From: Colin Gurr <colin.a.gurr@gmail.com>
Sent: 16 July 2020 12:37
To: Rebekah Morgan
Subject: Fwd: REF 16/00472/OUT

I write in reference to the above planning application of 200 dwellings on the Grundon Waste Management site.

### Site Access

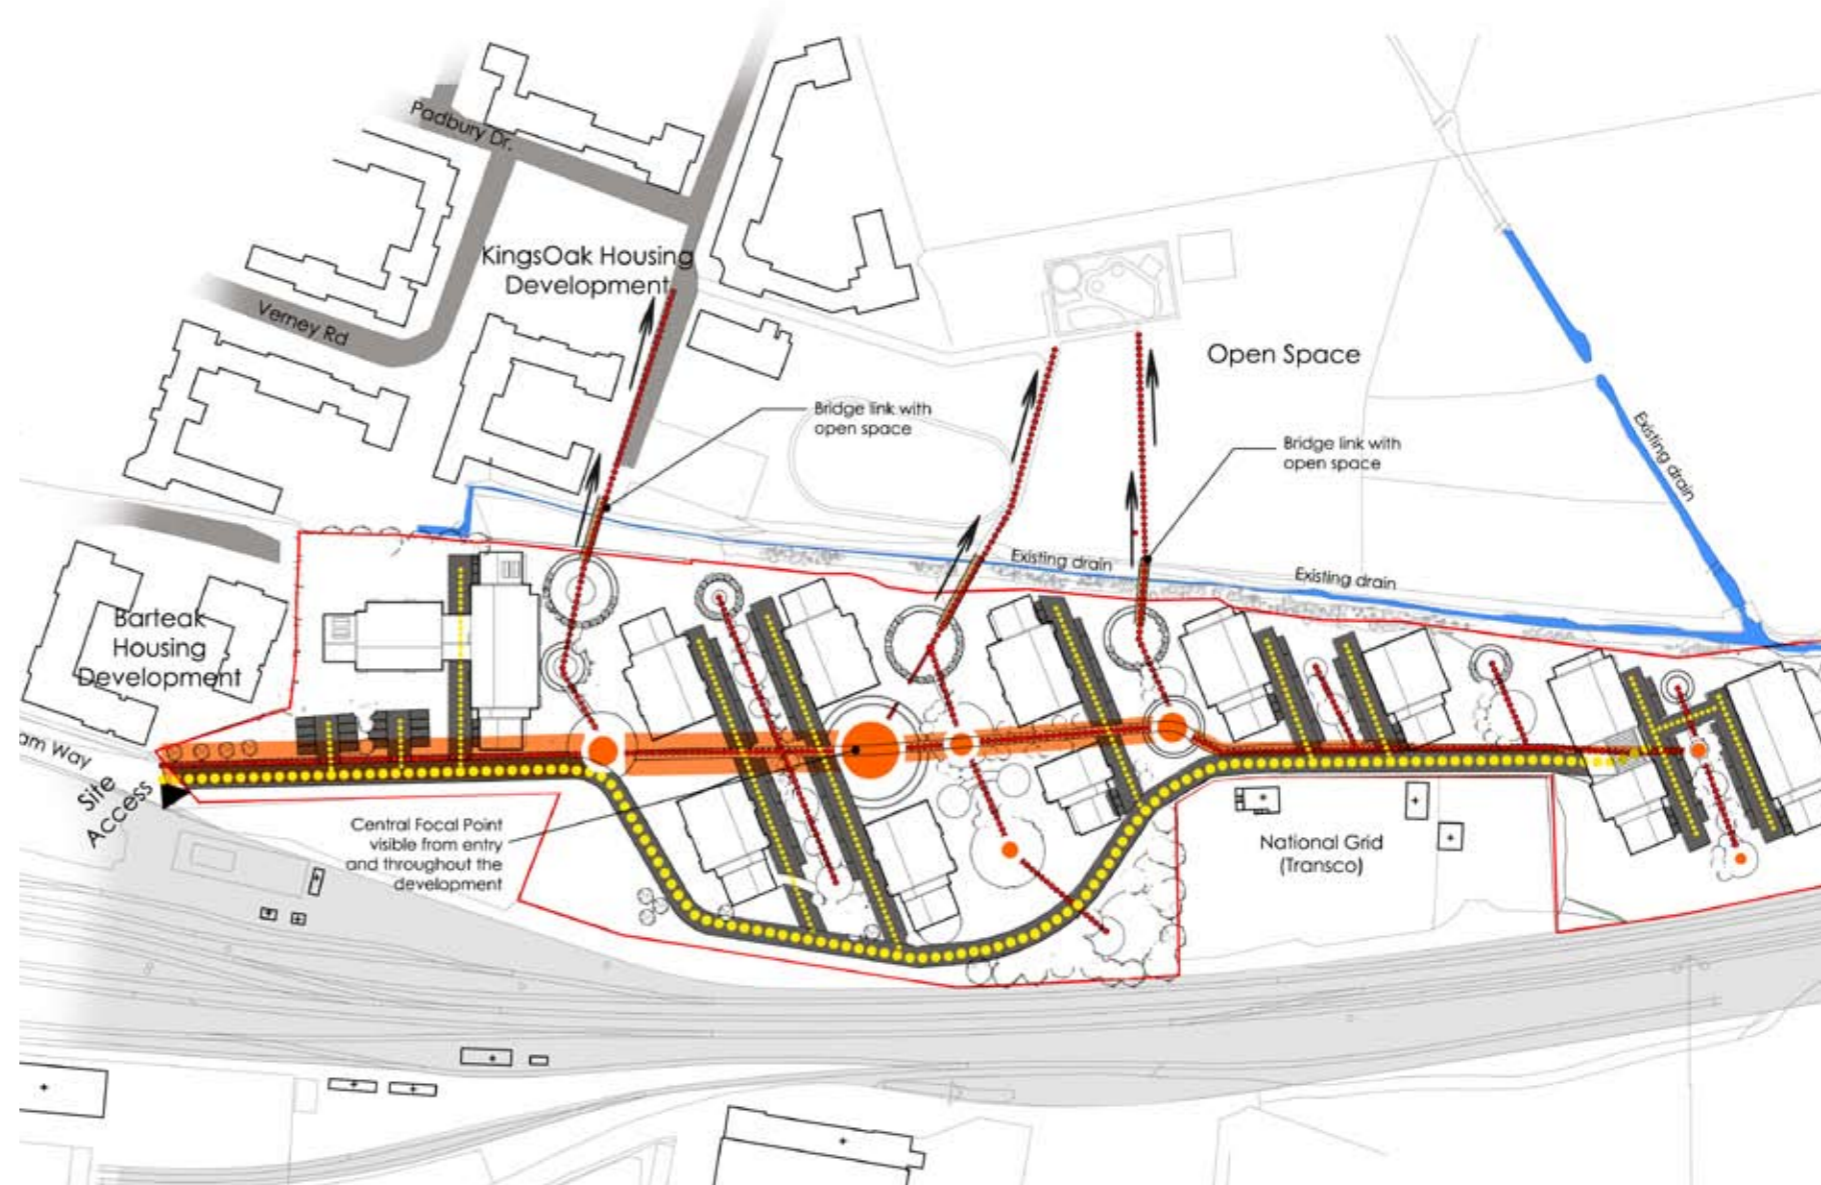
This hasn't been thought through. I refer AGAIN to the junction where Alma meets Higham Way. It isn't wide enough. How do you propose this works when we cannot exit this junction? Nothing can leave it and nothing can enter it? It is going to cause road rage and anger for many.

The road network cannot cope. Have you seen that where Alma Road meets Higham Way how wide this is? No probably not. When cars exit Alma onto Higham Way two cars cannot pass each other with enough space safely. When the traffic backs up to this junction which it will because it already queues up past the Chiltern Railways Car Park it is going to cause absolute Havoc and safety issues. Cars will be forced up the pavements and collisions will no doubt at some point occur.

How do you expect me to be able to turn right onto Higham Way when I cannot leave that junction because the traffic is gridlocked and furthermore how do cars turn left into Alma Road when I am blocking that narrow junction and cars cannot pass.
